ARCHITECTURAL INNOVATIONS, P.S.

RE: AI Job #20012

Project Address: 7621 SE 22nd ST

Subject: Permit No. SUB21-006

SHEET 2 OF 4

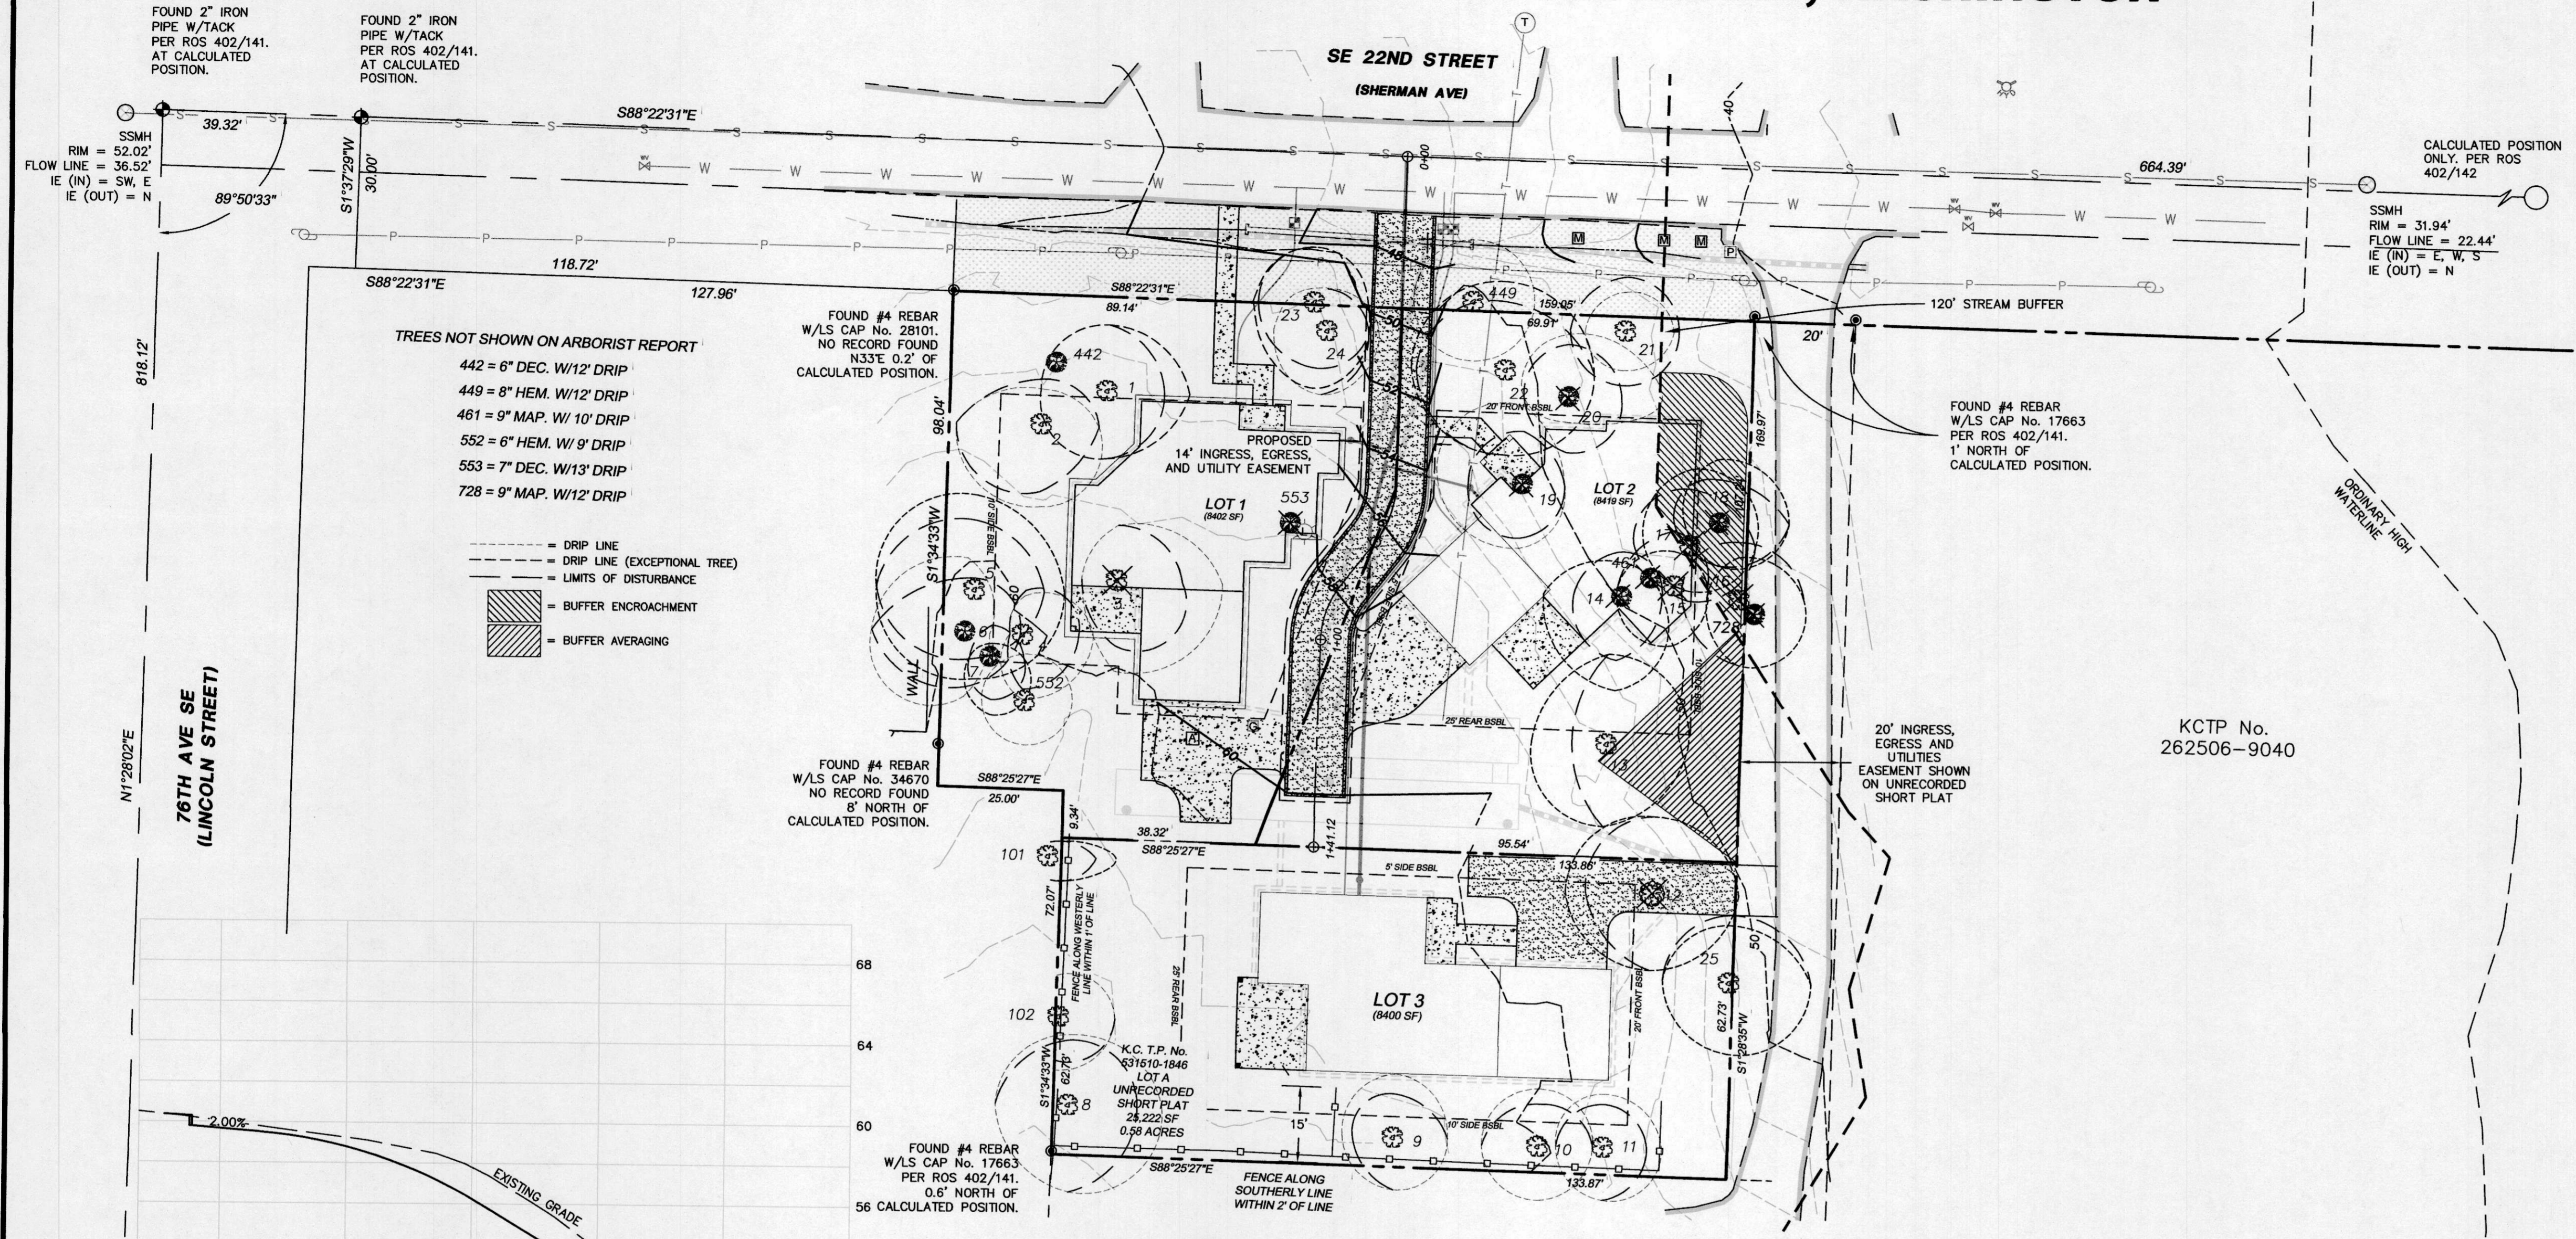
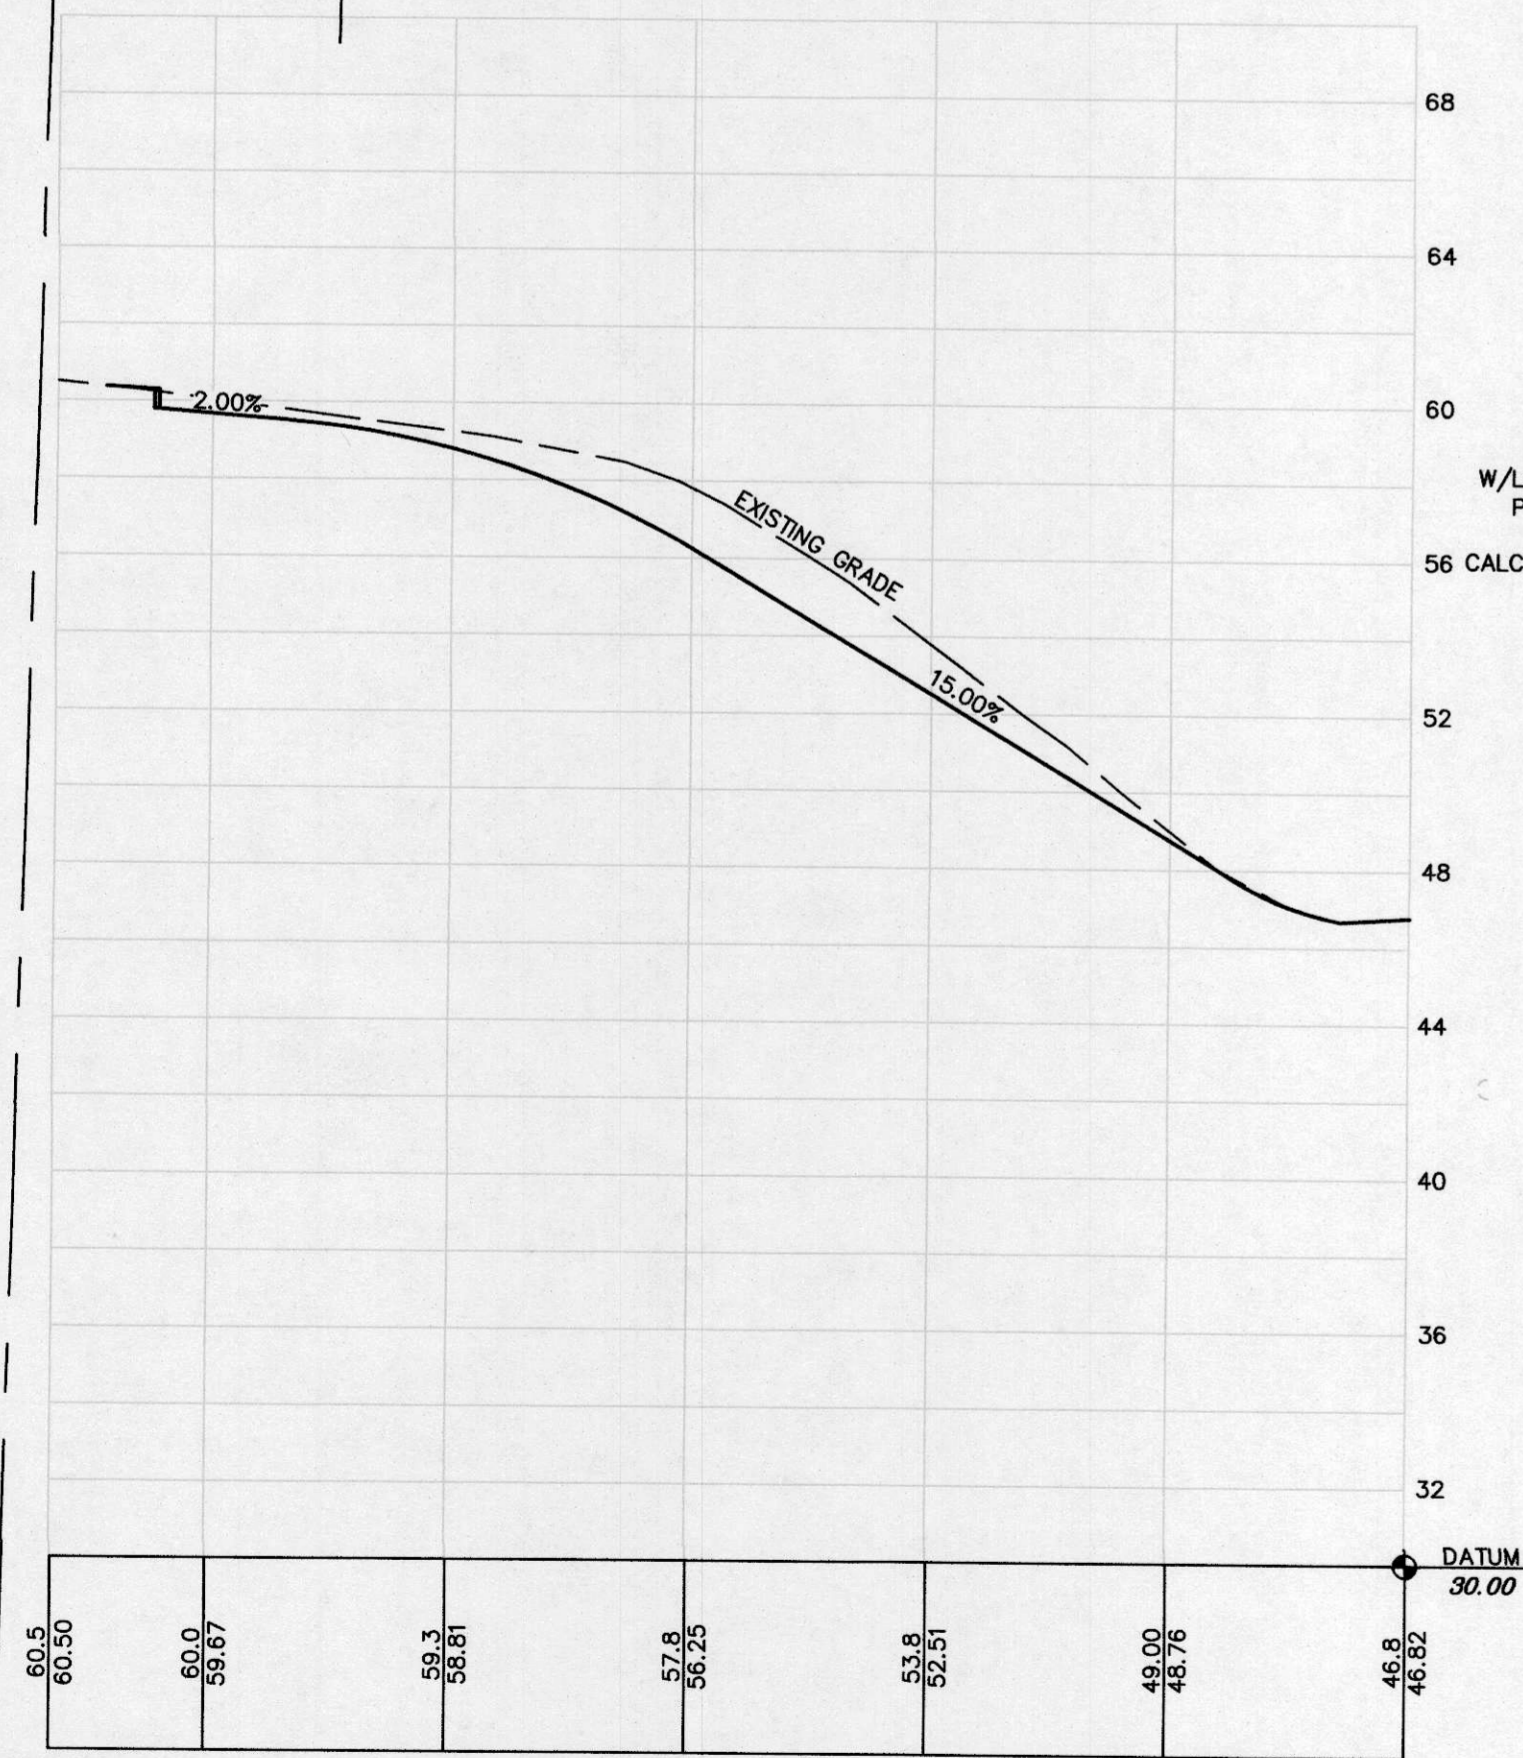
1. All of the driplines have been updated/added as well as the limits of disturbance.
2. We are requesting the removal of the exceptional grove trees, numbers 12, 14, 15,16,17 and 18. We believe we have met the requirements for the removal under MICC19.10.060.3 as the retainage of these trees effectively renders the lot unbuildable and we would see a reduction in the gross square footage allowed of approximately 1120 sf or about a 33% reduction in the from the allowed gross square footage. Further, the retainage of tree #12 eliminates any viable access for lot 3. The site was carefully laid out to preserve the maximum amount of trees to be retained. We are proposing to keep 62% of the existing trees and except for the aforementioned grove, we are keeping all of the exceptional trees.

3. All driplines and area of disturbance have been added/corrected. At this time, we would elect address the tree protection plan later as the building footprints are still a preliminary design.
4. The tree summary table and tree inventory & replacement form have been revised to reflect the exceptional status of the grove trees. With that said as proposed the current tree replacement quantity is 42 trees. With the amount of trees remaining on the lot and the room left we would like to request to do a Fee-in-Lieu of per 19.10.010.C.1 for a portion of the replacement trees.

# RAND-MILESTONE 3 LOT PRELIMINARY SHORT PLAT

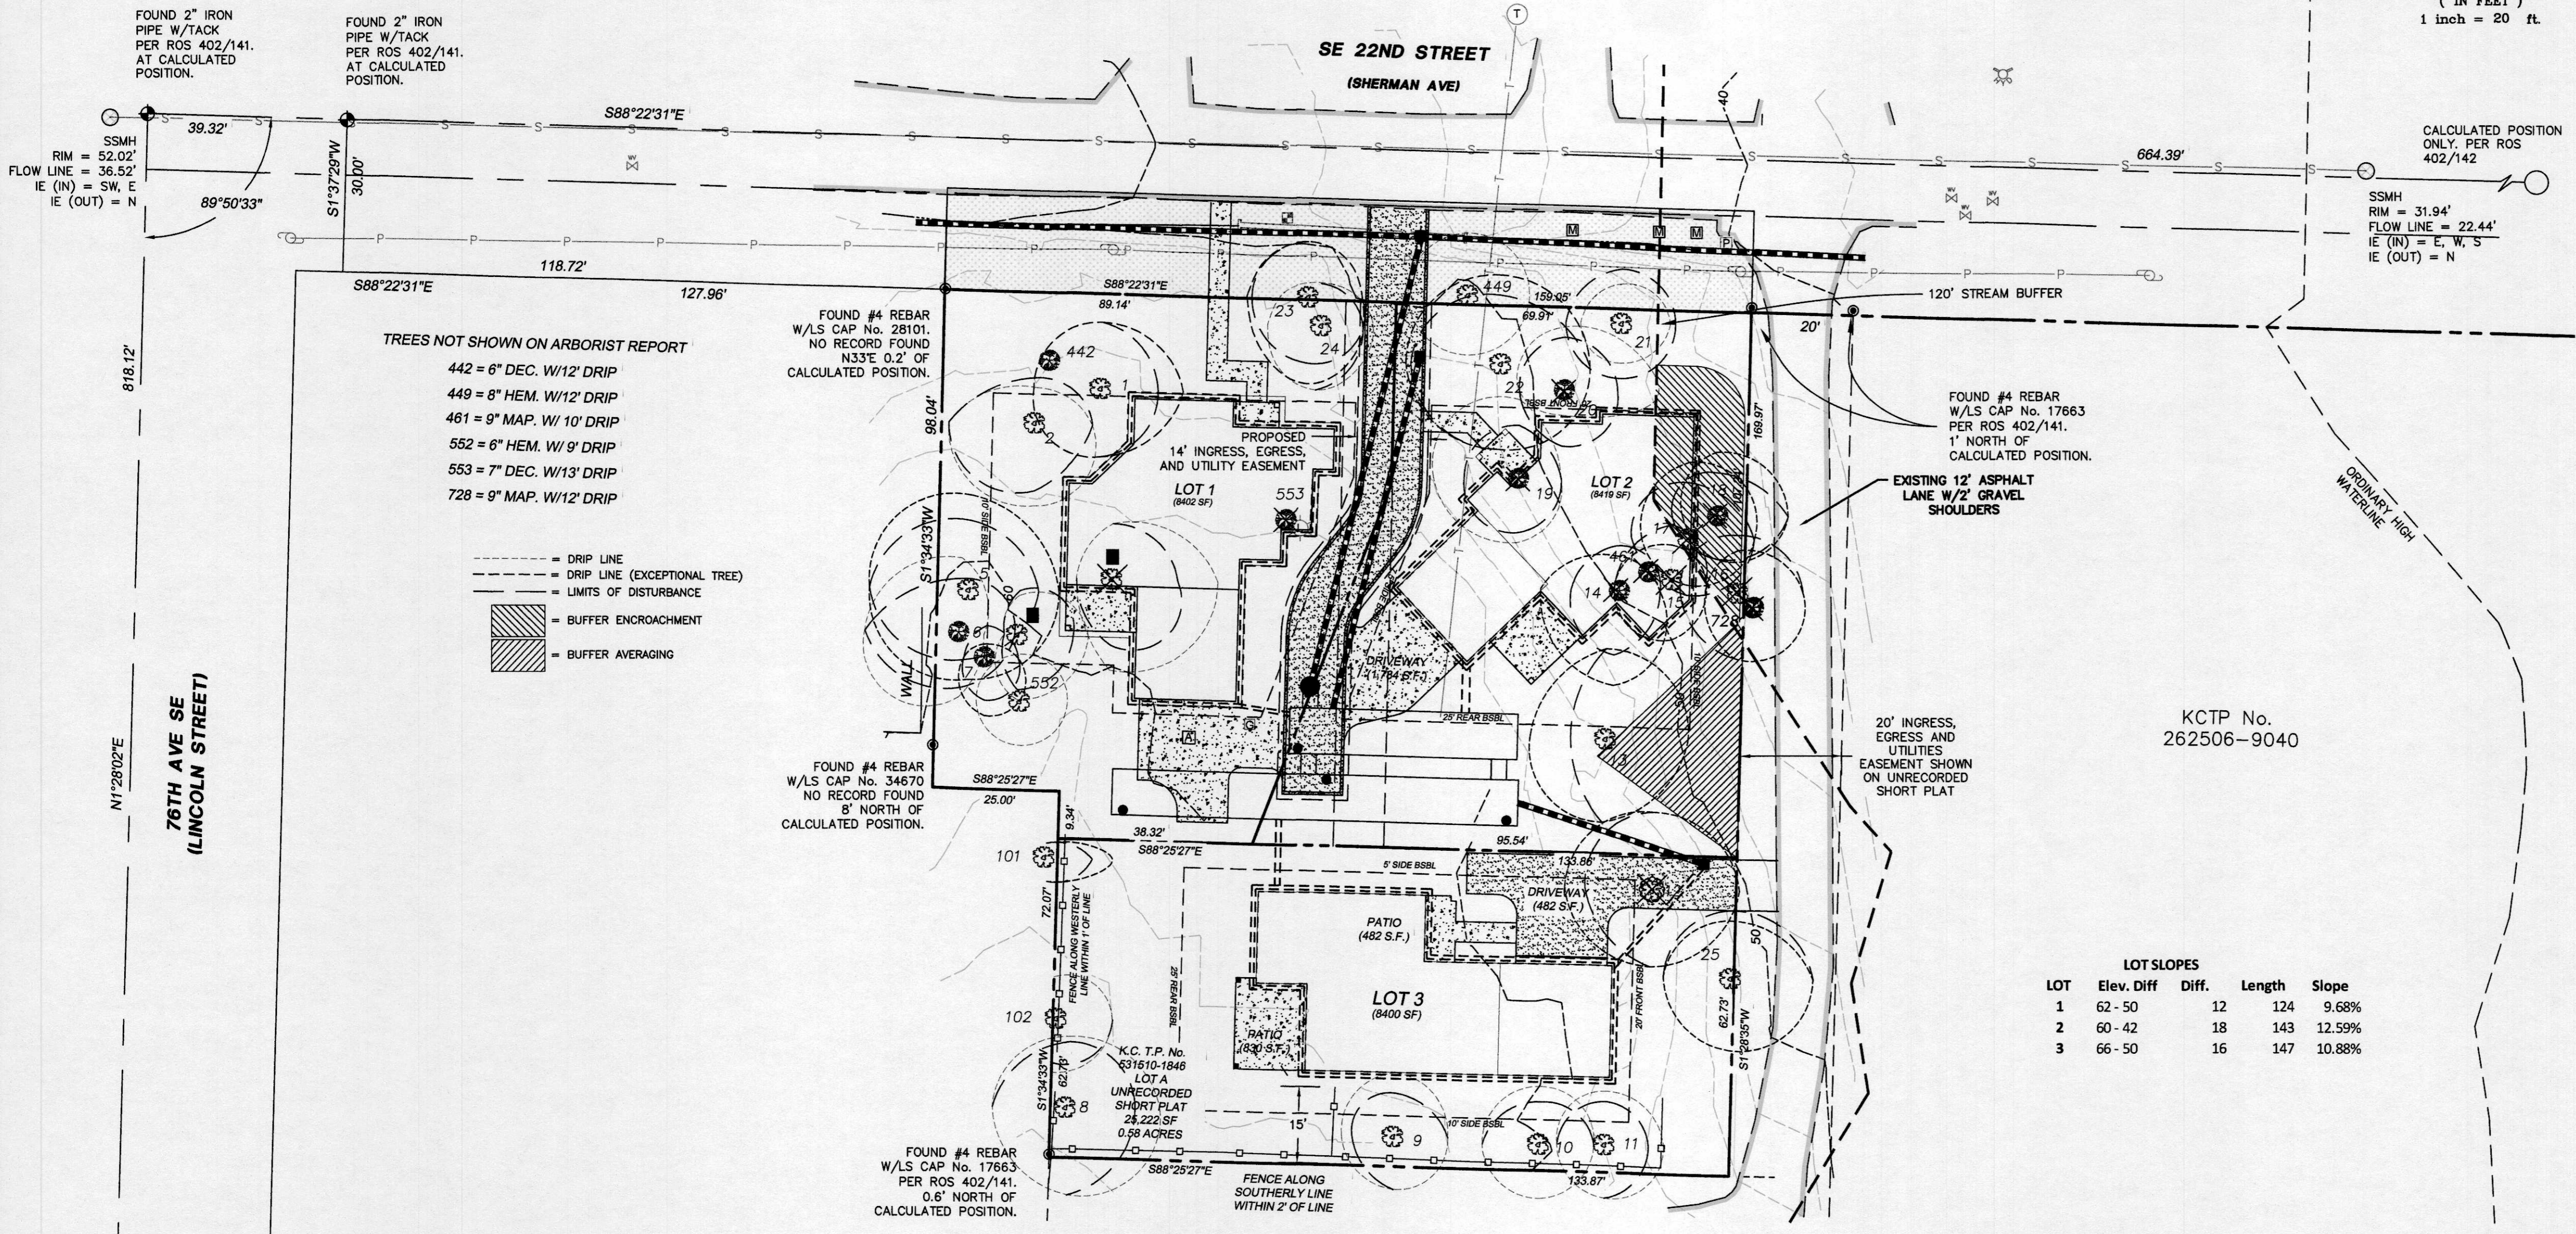
3. See item 2 above.
4. Existing lot dimensions, size, and coverage are noted on the survey. The preliminary site plan notes all proposed lot dimensions, lot size, and lot slope. As for coverage the footprints and hardscape areas are preliminary at this point. What is shown on the preliminary site plan represents the approximately the maximum allowable coverage.

5. All existing structures and hardscape are proposed to be removed. A note has been added to the preliminary site plan.
6. The note has been added to the preliminary site plan.
